**REQUEST**

Current Zoning: N1-A ANDO (Neighborhood 1-A, Airport Noise Disclosure Overlay)  
Proposed Zoning: N2-A(CD) ANDO (Neighborhood 2-A, Conditional, Airport Noise Disclosure Overlay)

Approximately 15.87 acres located on the east side of Sandy Porter Road, south of Arrowood Road, and north of Steelechase Drive.

The petition proposes to redevelop several properties occupied by single-family dwellings with a community of 194 multi-family attached dwellings.

RZ-1.0

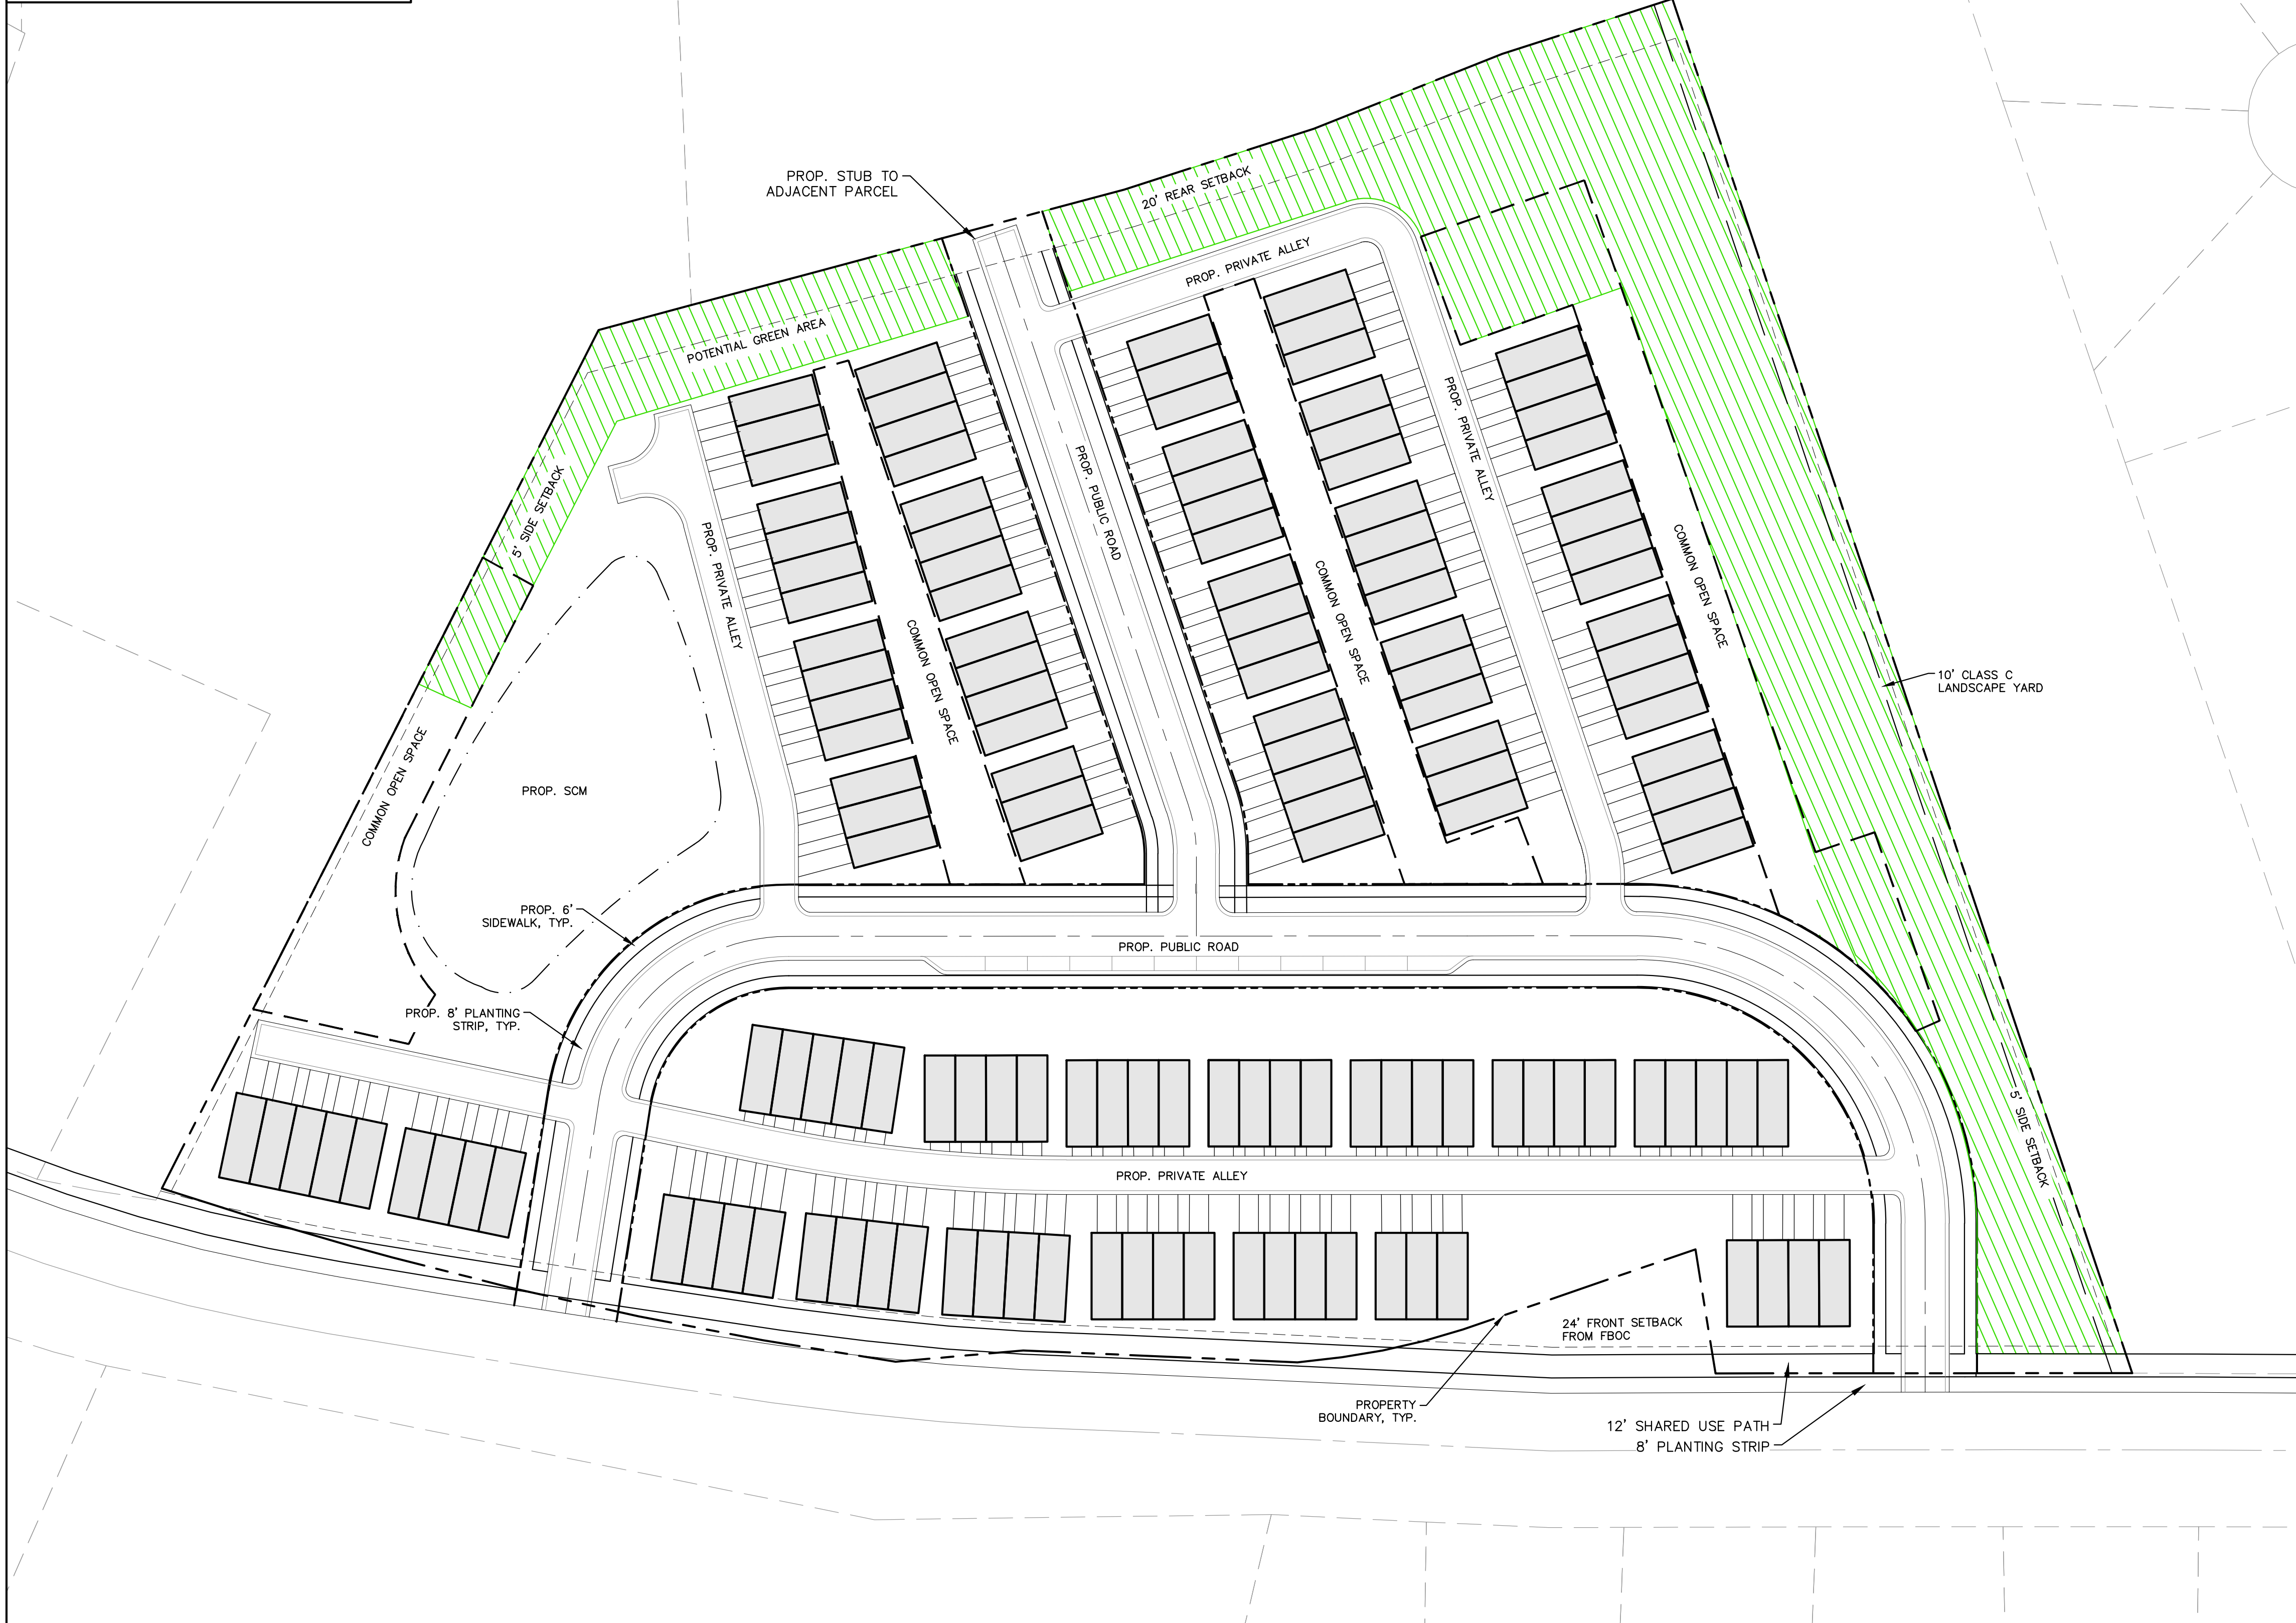
1. Show, dimension, and label in streetscape on all internal public streets. Internal public streets are to be U-03 with 8ft planting strip and 6ft sidewalk and on-street parking. All public streets must have on-street parking where feasible.
2. Revise site plan to modify right-of-way boundaries as illustrated in the CDOT memo.
3. Revise the site plan to show existing edge of pavement and all existing striping on Sandy Porter. Site plan should clearly show lane configurations along Sandy Porter adjacent to the project and how the project will tie in at either end of the project.
4. Revise Transportation note 11 to correct "rights-of-way" typo.

5. Green area must be comprised of existing tree canopy. Most of the southern area does not have existing canopy or the canopy is from trees on the adjoining property that cannot be used.
